## Mallard Pass Solar Farm

### Environmental Statement Volume 2 Appendix 10.3: Noise and Vibration - Consultation Summary

Document Ref: EN010127/APP/6.2

### **Appendix 10.3 - Consultation Record and Responses Relevant to Noise and Vibration**

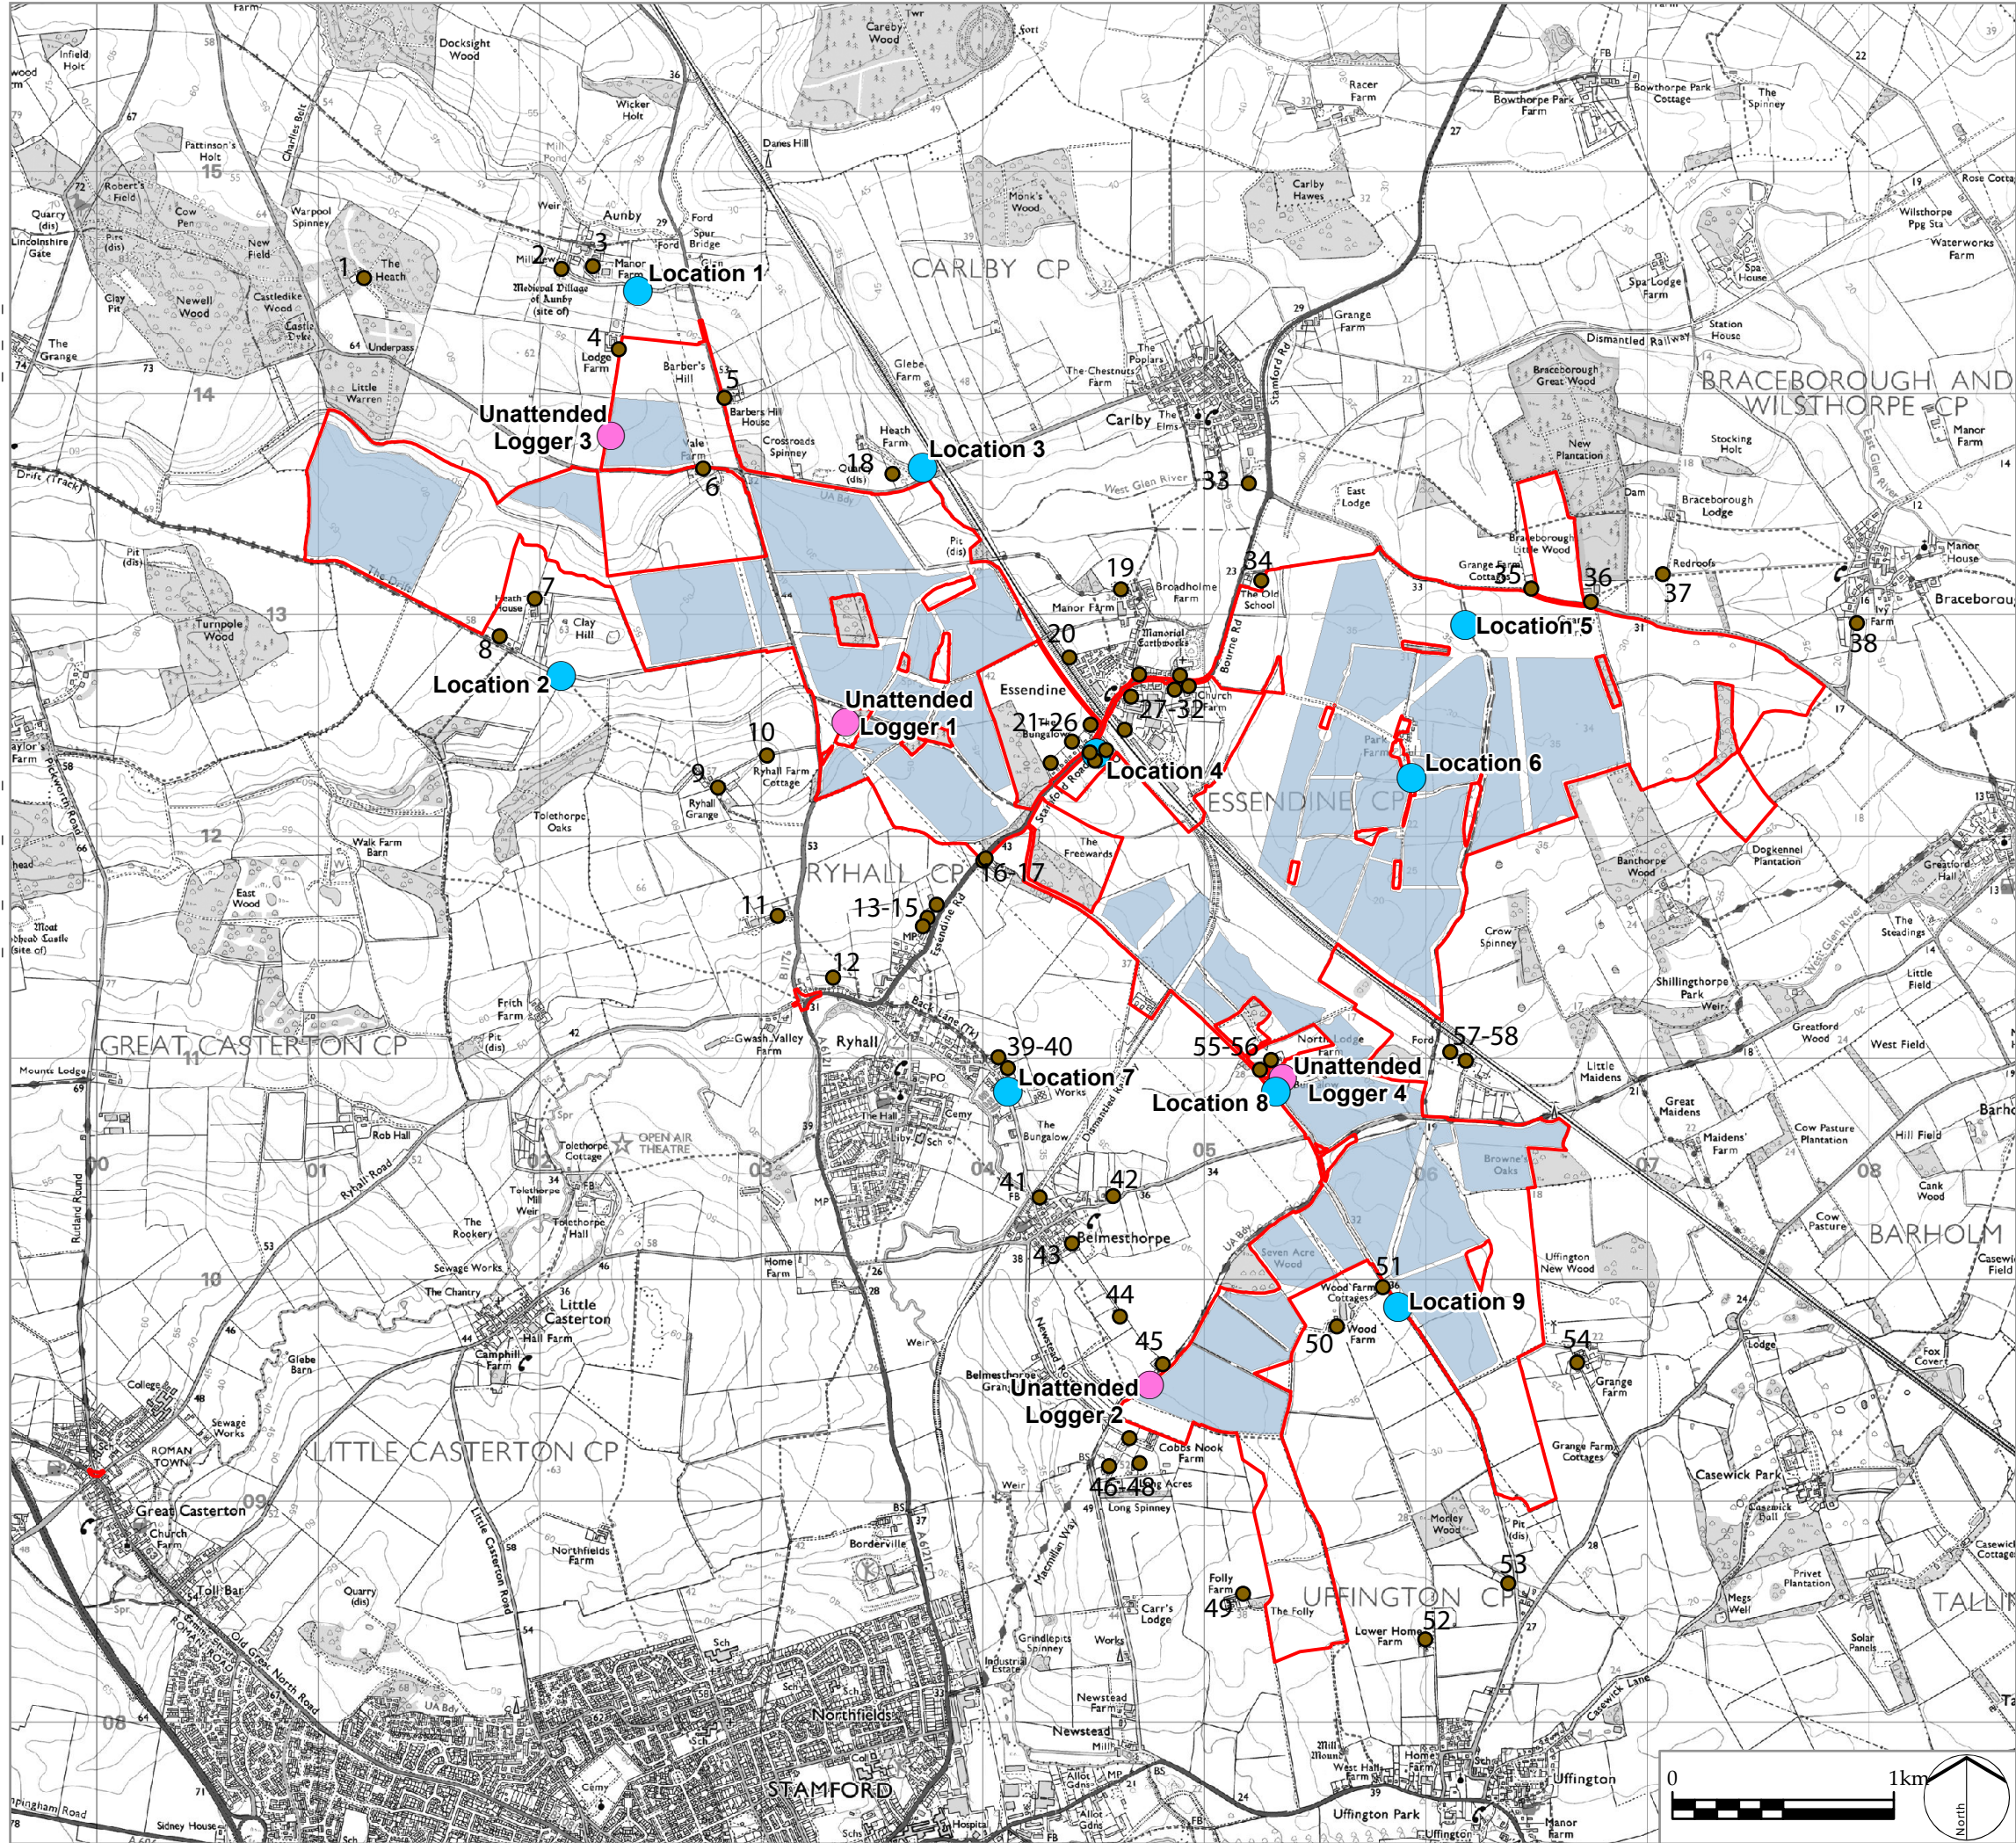
Planning Inspectorate (PINS) - Scoping Opinion	March 2022	The noise assessment should consider the potential emissions of solar tracker panels (SAT).	This was modelled and considered as part of the assessment.	Chapter 10 and Appendix 10.5.
Greatford PC – scoping opinion	March 2022	Consultee raised potential noise-sensitive receptors: stressing those along construction access route and querying completeness of receptor list provided in scoping report.	Construction traffic noise assessment considers all receptors along route. It has been clarified that the assessment of noise effects considers a	See Chapter 10, <b>section 10.2</b> for clarification. Receptors are shown in <b>Figure 10.1</b> .
